Planning Application Ref: AL/126/21/PL

Location: Ryefields Farmhouse, Oak Tree Lane, Woodgate, PO20 3GU

Description of works: Demolition of existing building and erection of 5no. houses comprising 1no. 4-bed detached, 2no. 4-bed link detached & 2no. 3-bed detached houses with associated access & parking (resubmission of AL/81/21/PL). This site falls within Strategic Site SD5, CIL Zone 1 (Zero Rated).

Mark Warwick
Tree Officer / Parks and Greenspace Team

Ryefields Farmhouse, Oak Tree Lane

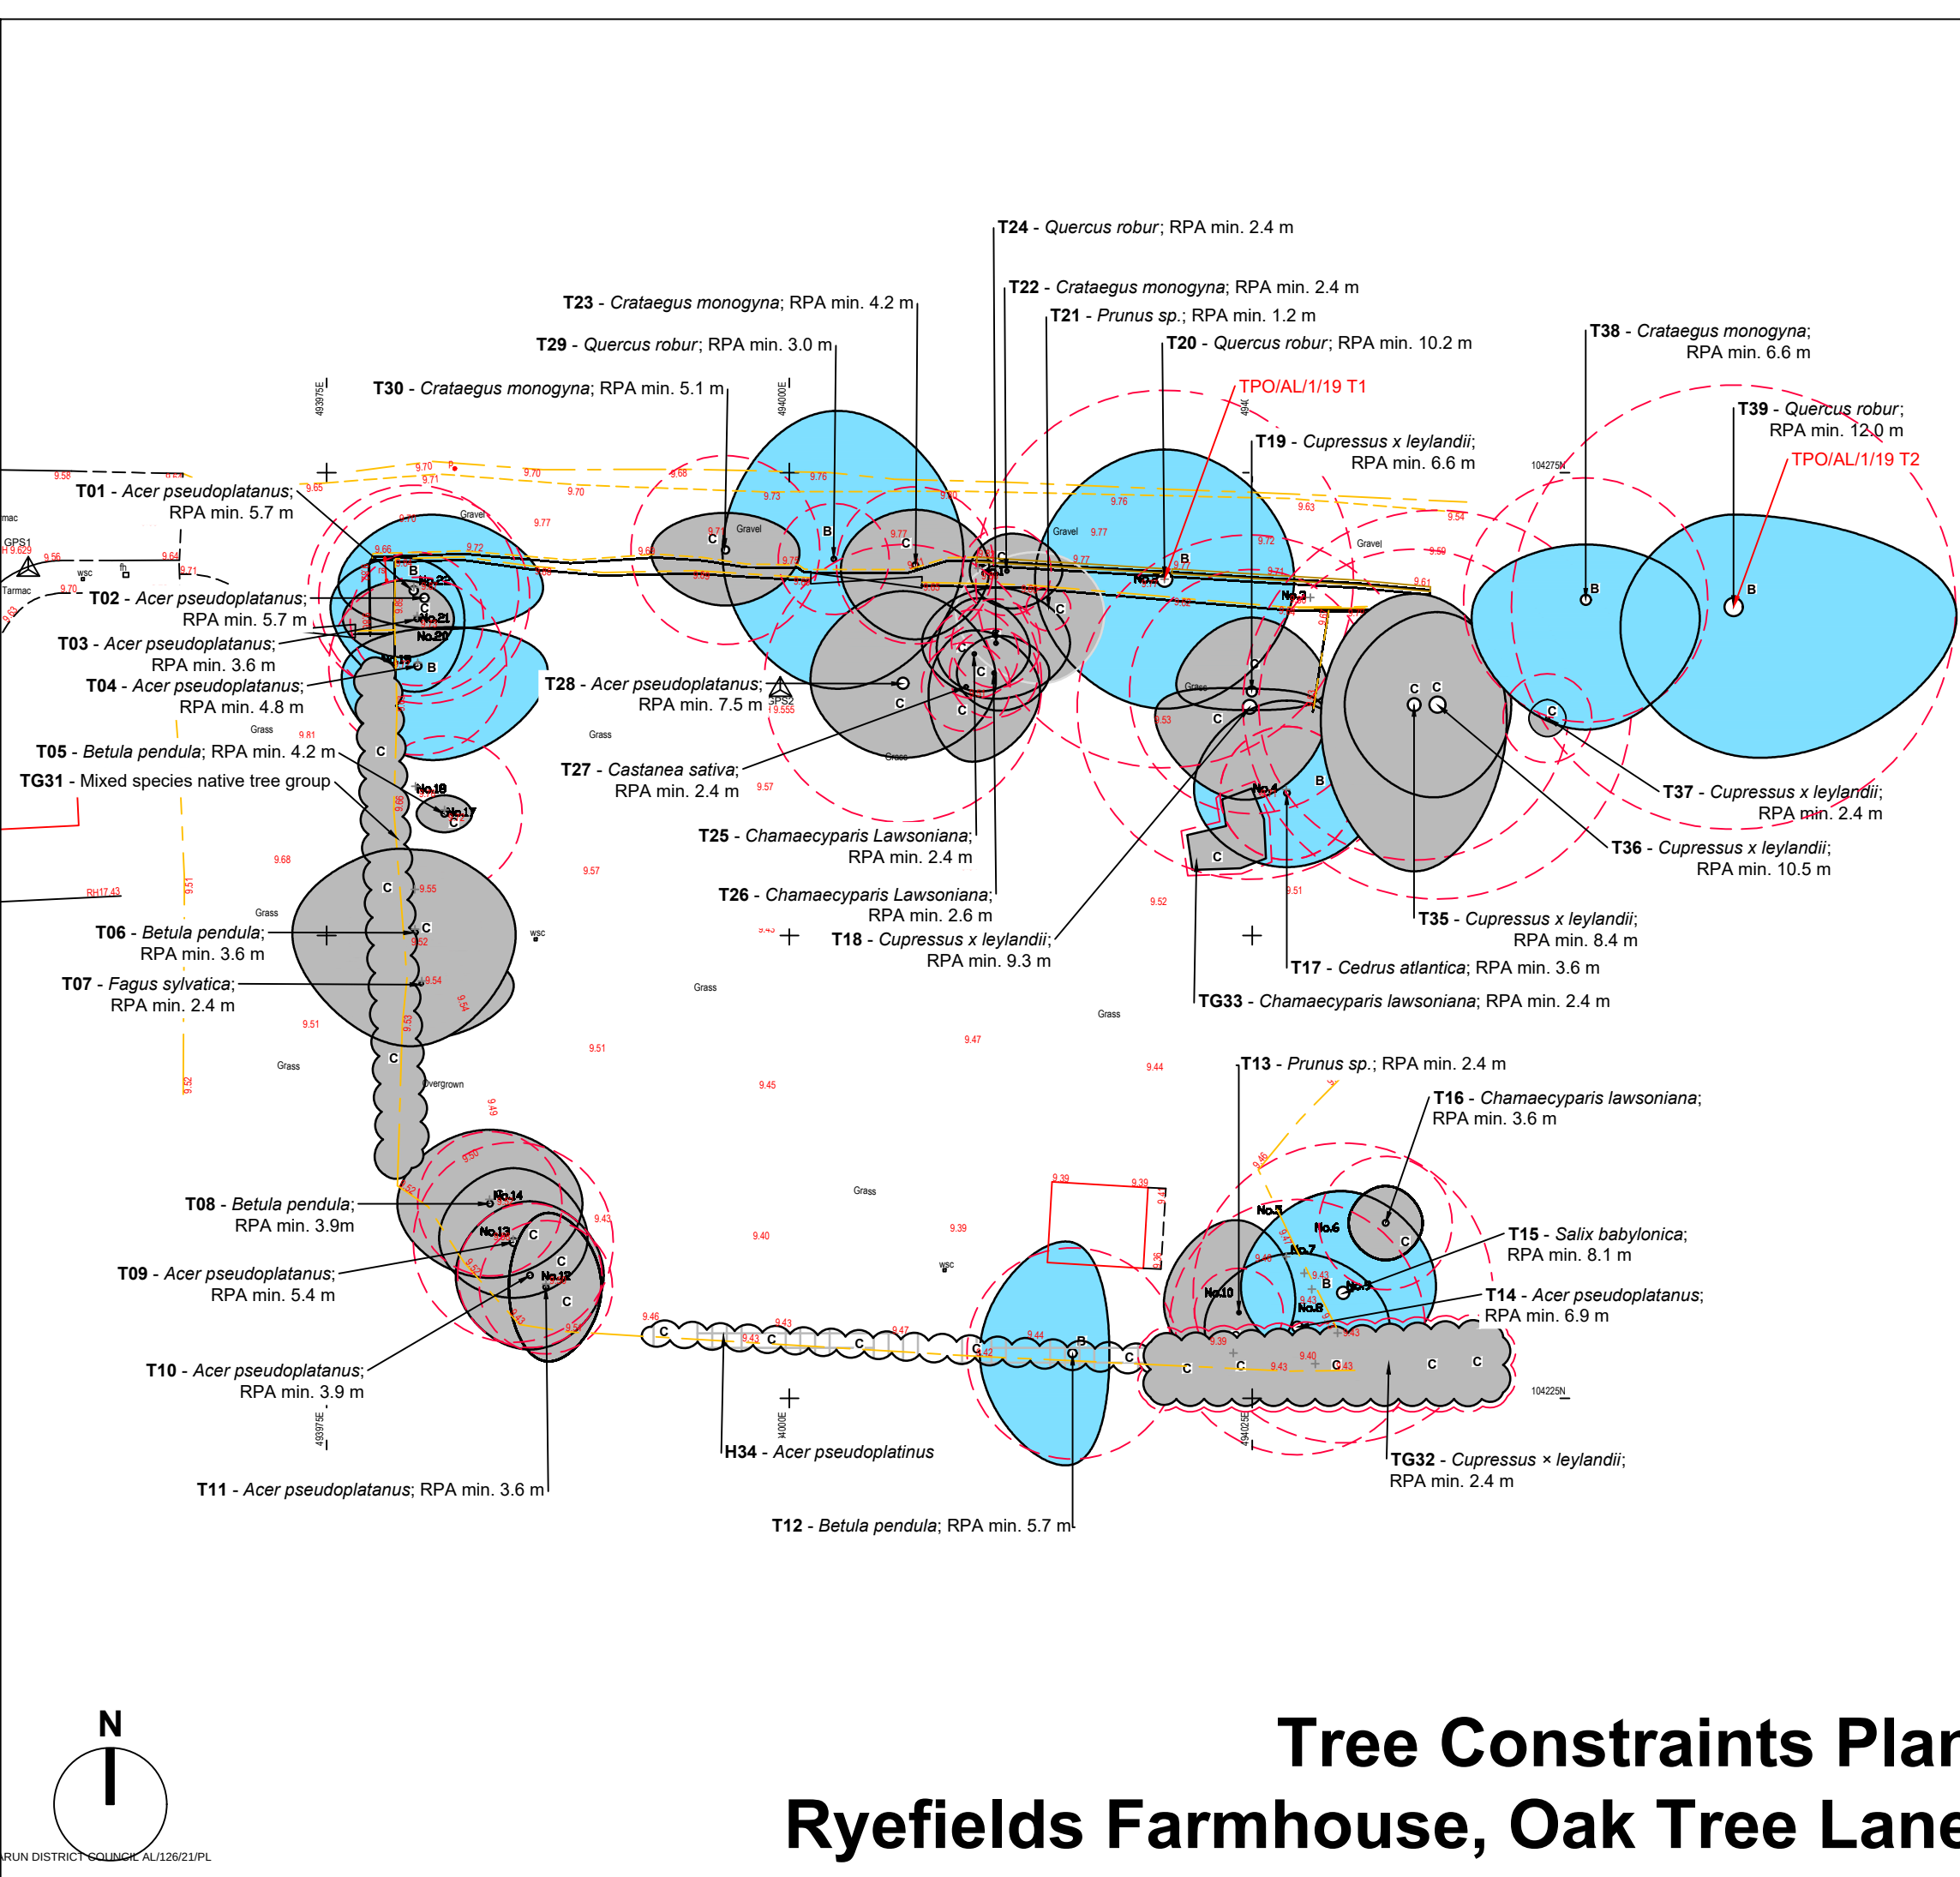
- This latest proposal appears more sympathetic to its predecessor in that it seeks to retain the mature oak (subject of a Preservation Order) T20. Unfortunately, both T20 and its companion oak T39 (subject of the same TPO) will be impacted by the installation of a car parking area. A no-dig construction method is to be employed.

- The combined extent of ground protection and no-dig construction areas, as shown on the TRP plan is already extensive. Whilst they propose recognised engineering solutions for working in close proximity to retained trees, it must be noted that that element is very ambitious and carries a high risk of accidental damage.

- It is important to consider the greater volume of the oak trees' roots would likely be found within the development site and so any RPA incursion (irrespective of mitigation measures) may be more extensive than apparent on the plans.

- Several trees proposed for removal appear to be off-site and in 3rd party ownership.
